Our ref: B/25/0225

**Re: EN 010151 - Beacon Fen Energy Park**

**Boston Borough Council's - Deadline Two Submission - 21<sup>st</sup> October 2025.**

Figure 6.32 Vegetation Removal Plan
Document Reference: 6.4 ES Volume 3, 6.4.43a
April 2025

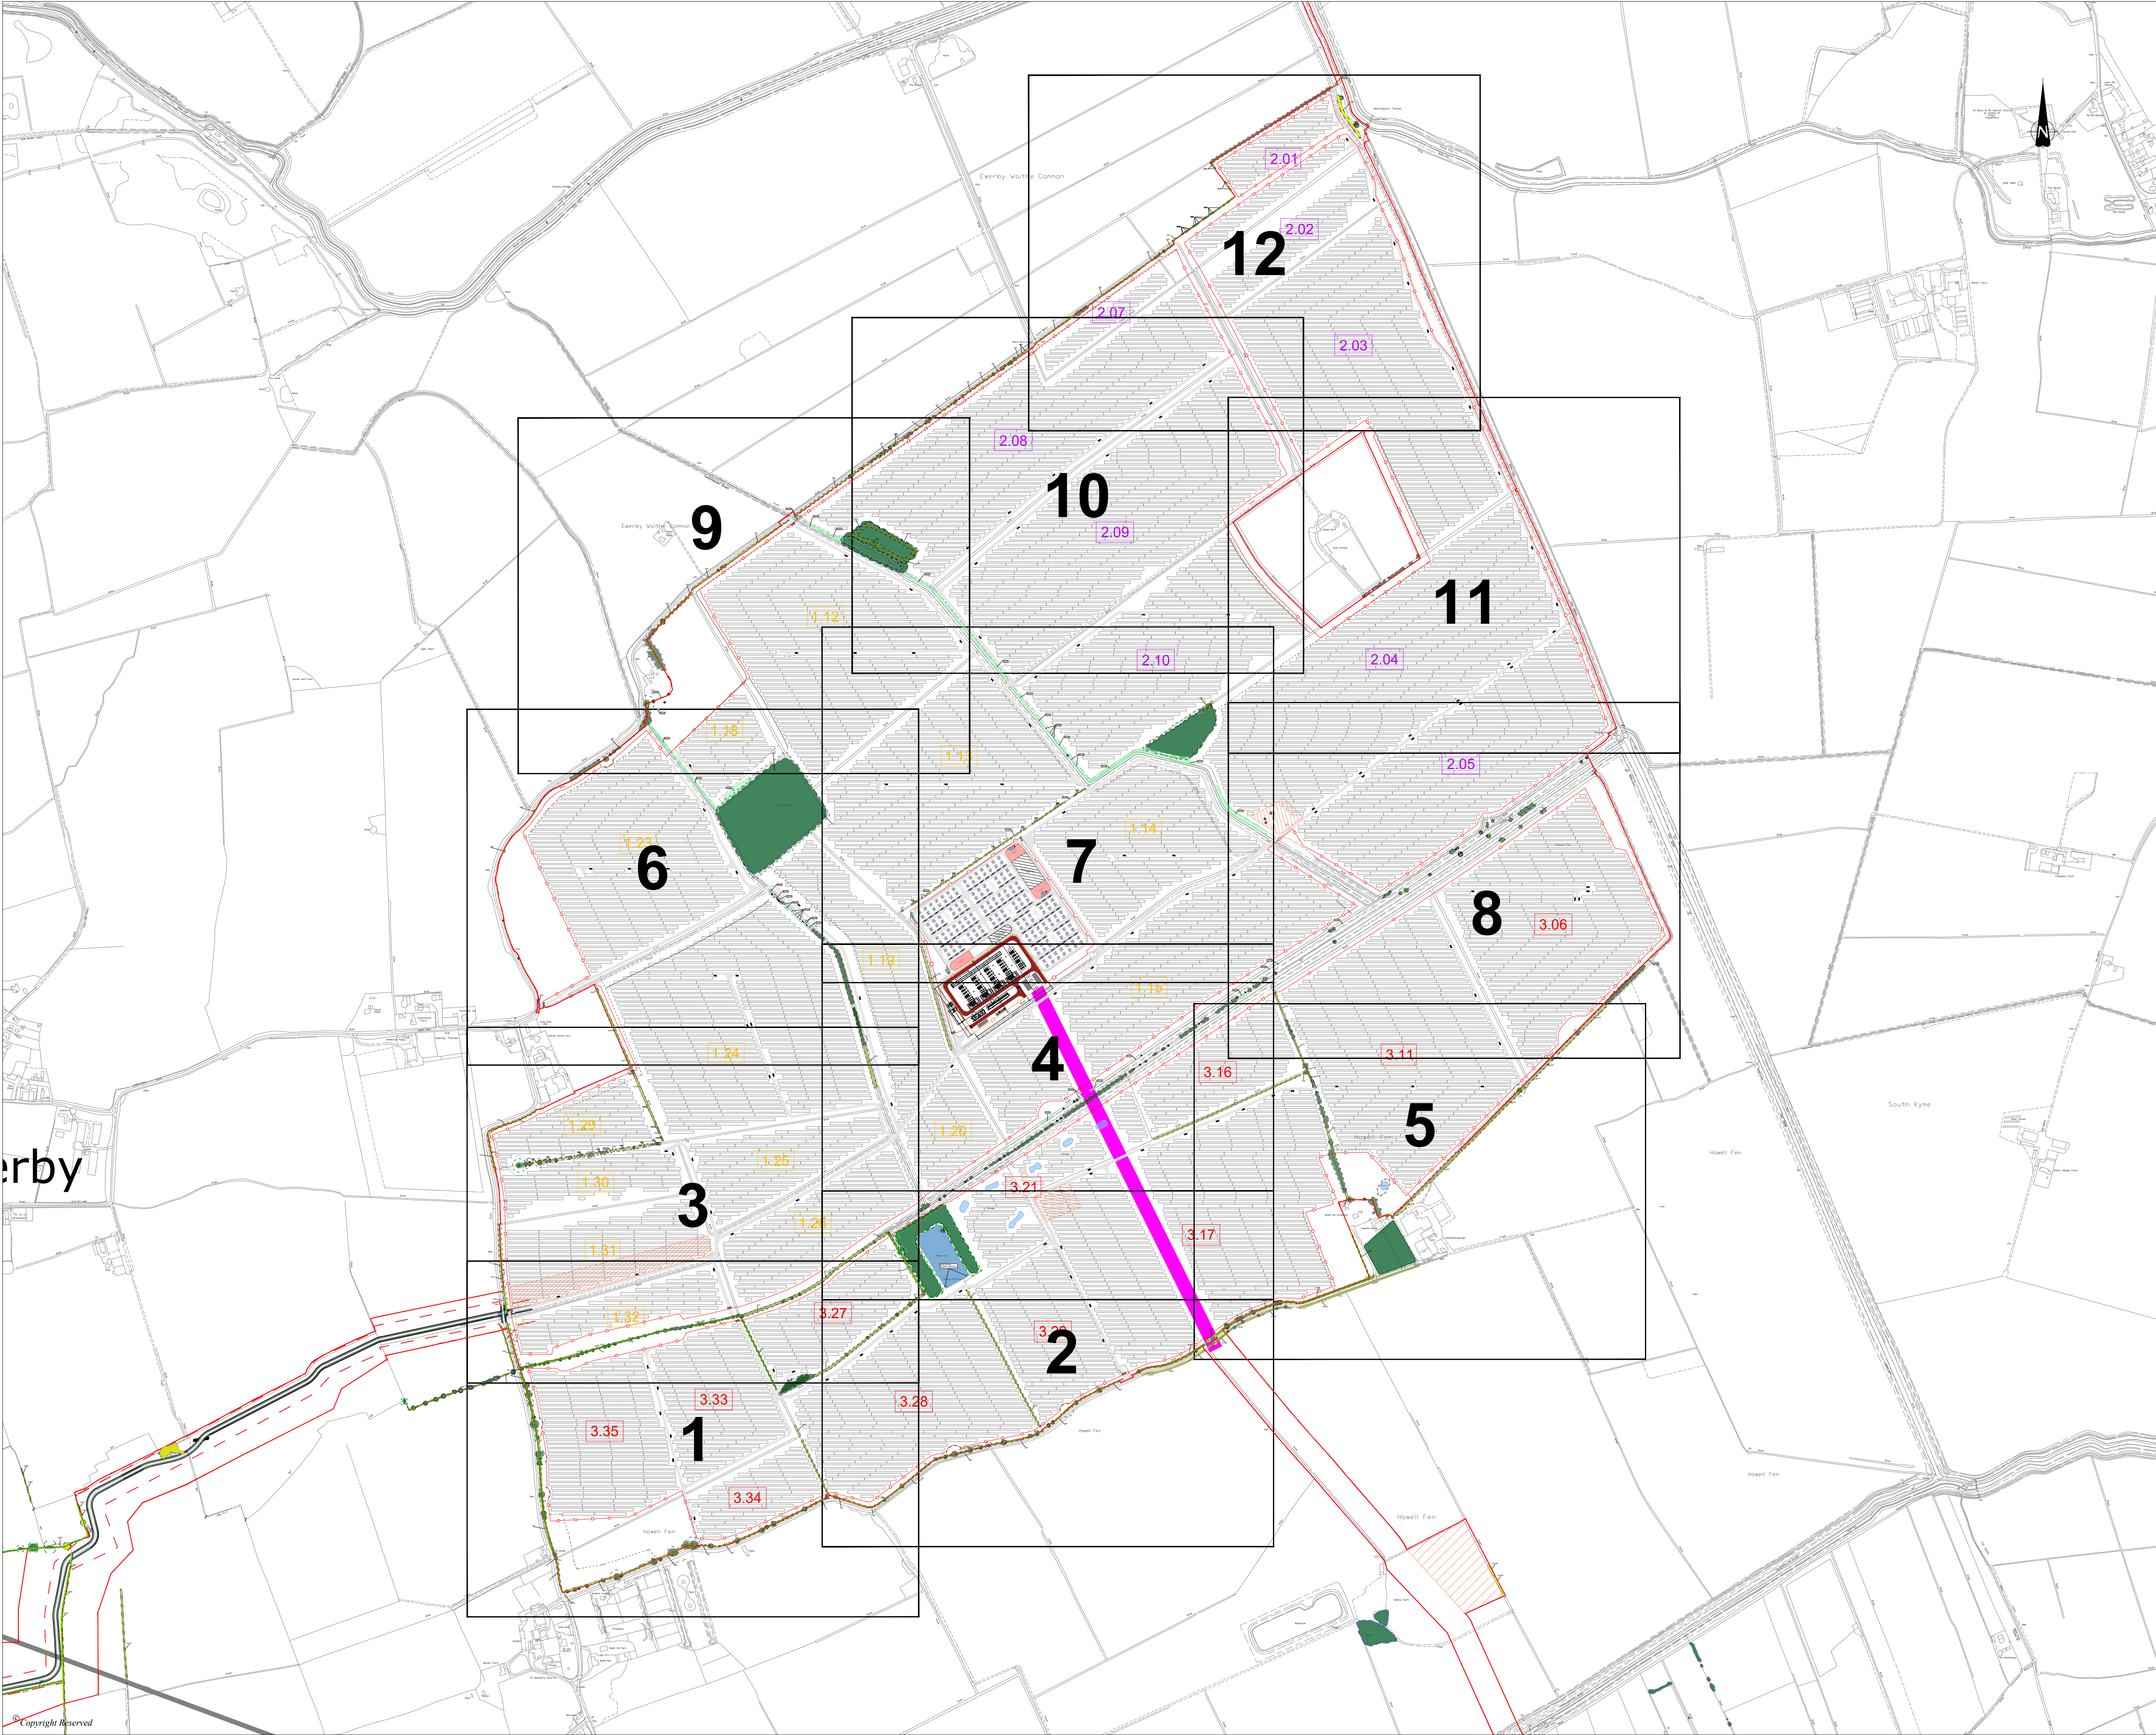
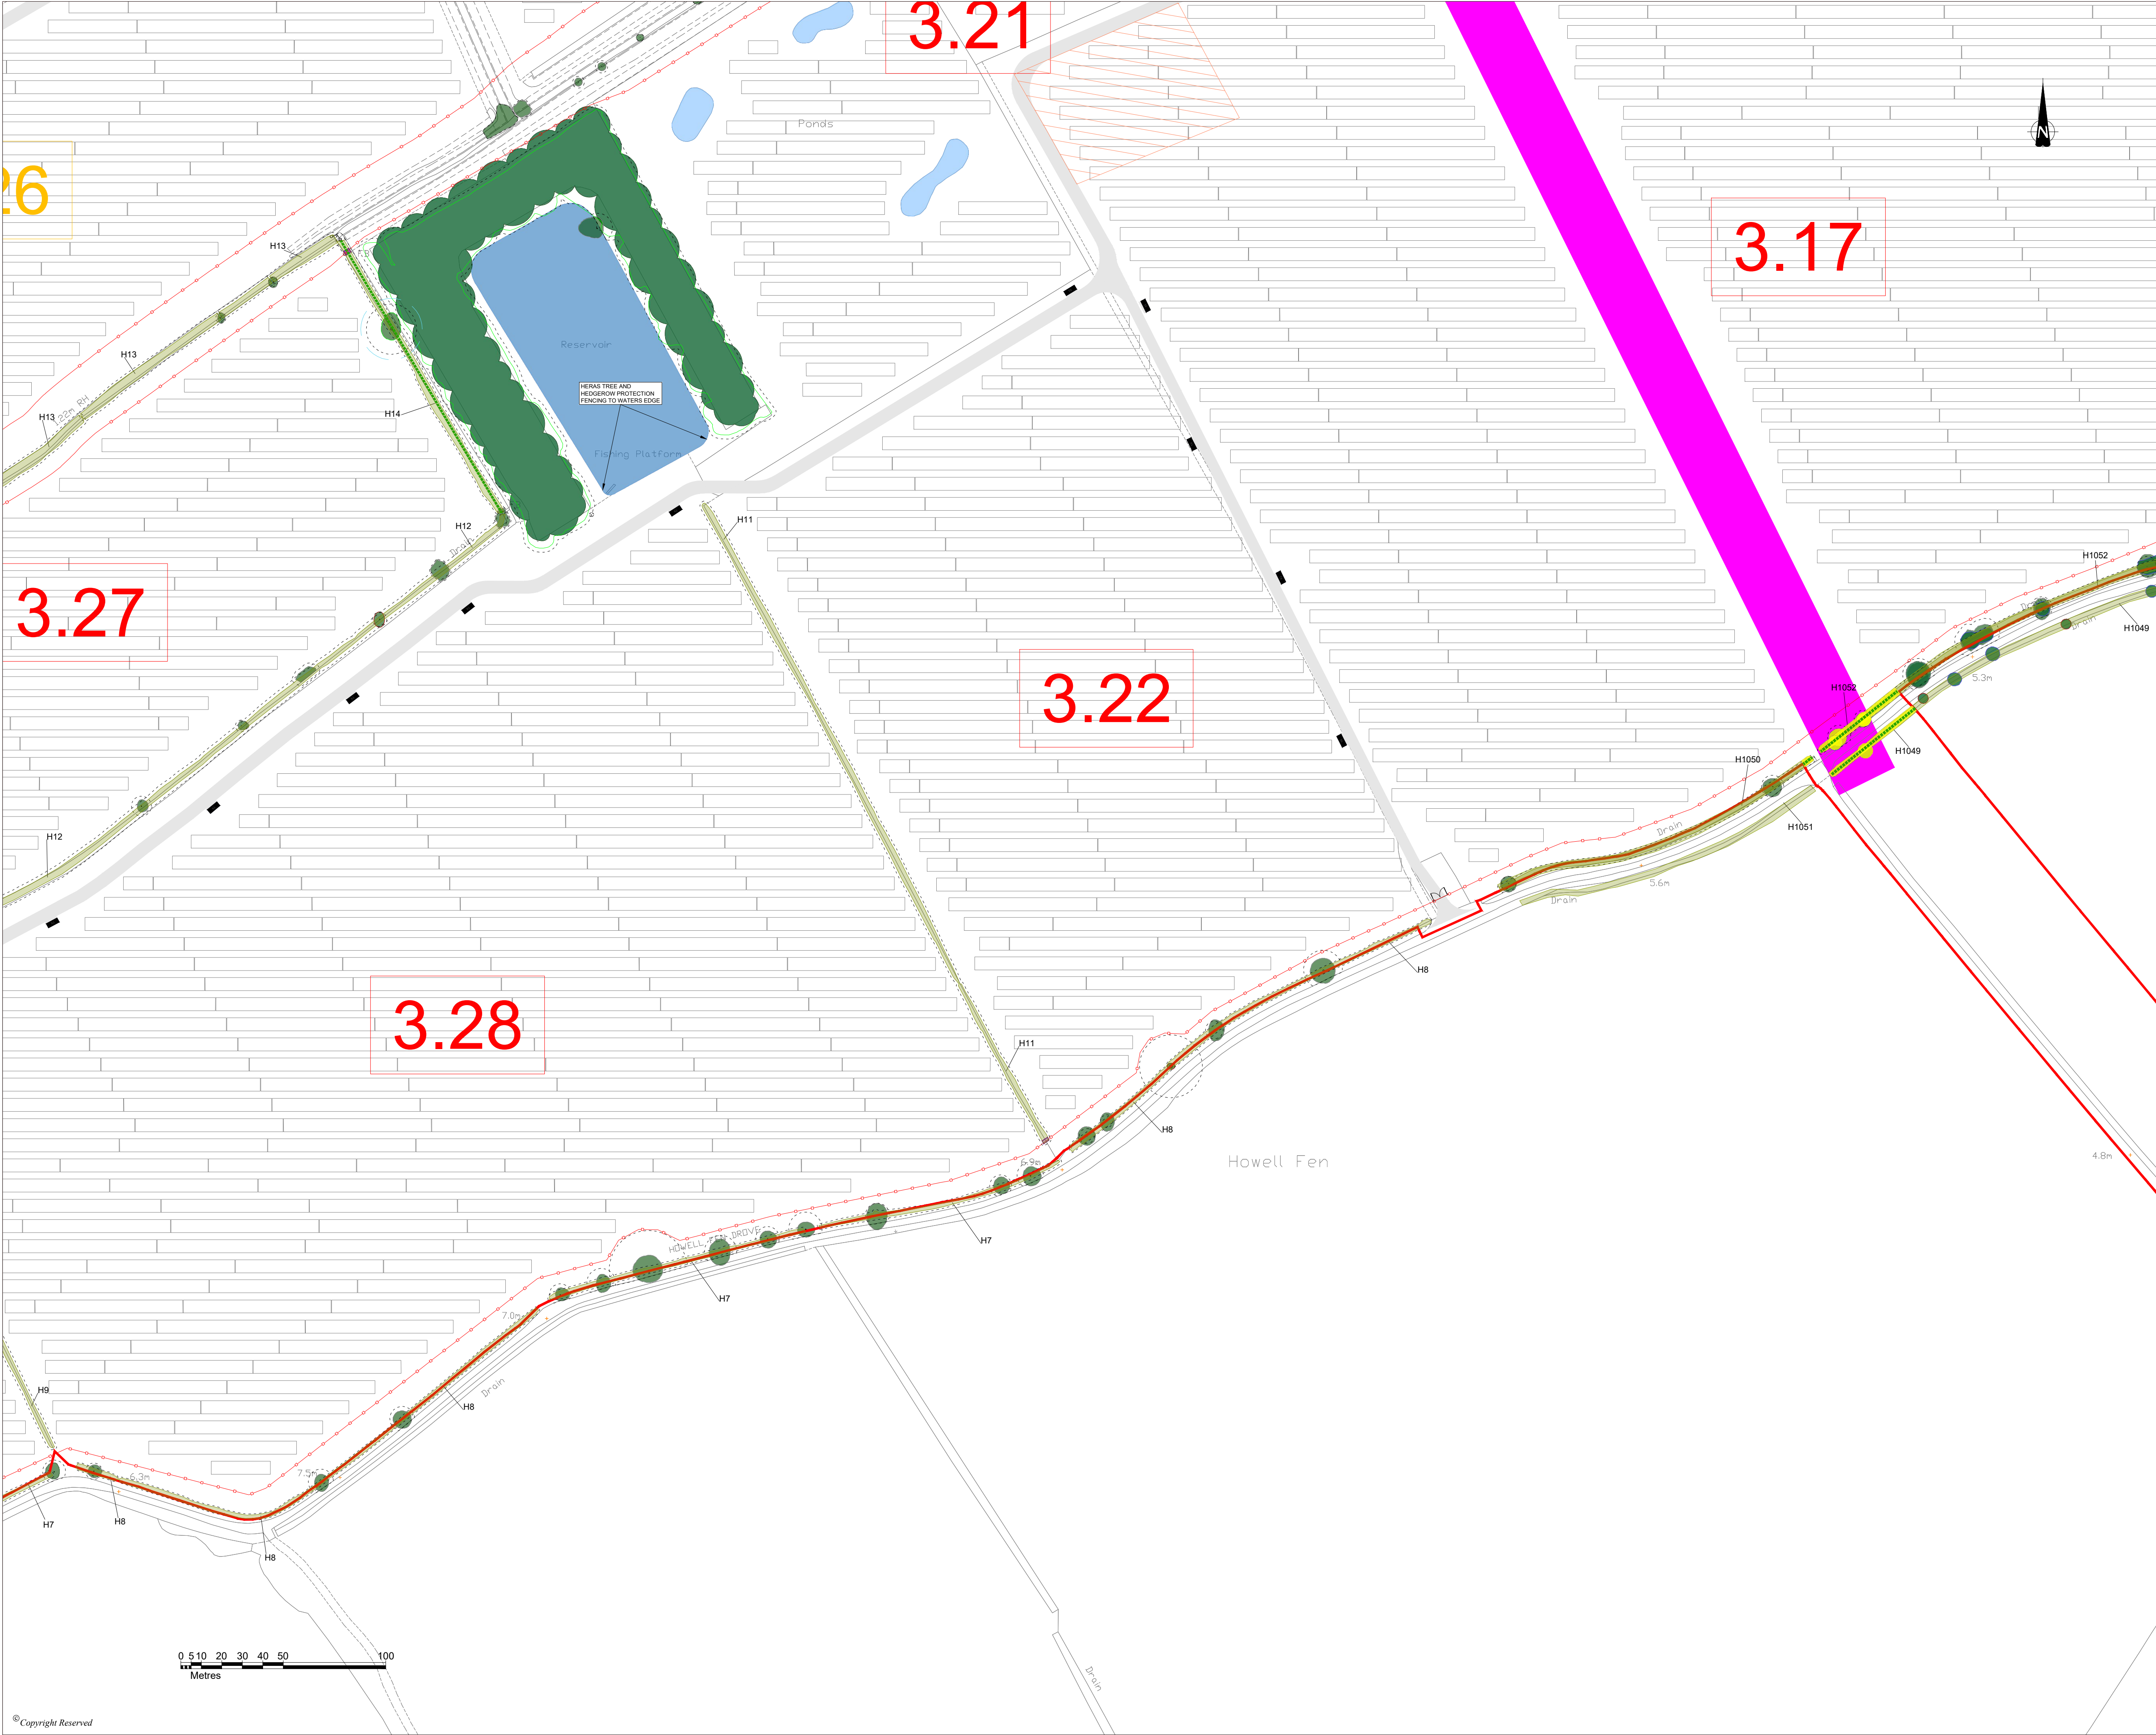
BBC welcomes the Applicant's update to Figure 6.32 Vegetation Removal Plan (REP1-015) that provides the following clarification;

- that there will be no requirement to remove existing vegetation within the South Forty Foot Drain; and
- of the extent of potential vegetation removal and retention at Bicker Fen Substation.

BBC seeks further clarity on how the vegetation shown as retained on the updated Vegetation Removal Plan and the Vegetation to be removed are secured within the Requirements of the draft DCO.

BBC wishes to ensure that vegetation shown as retained on the updated Vegetation Removal Plan and the Vegetation to be removed are secured and approved by the relevant Planning Authority within the Requirements of the draft DCO.

As noted above the Applicants update to the Vegetation Removal Plan is welcomed and provides the necessary clarity at this location provided that vegetation shown as retained on the updated Vegetation Removal Plan are adequately secured and that they will be approved by the relevant Planning Authority within the Requirements of the draft DCO.
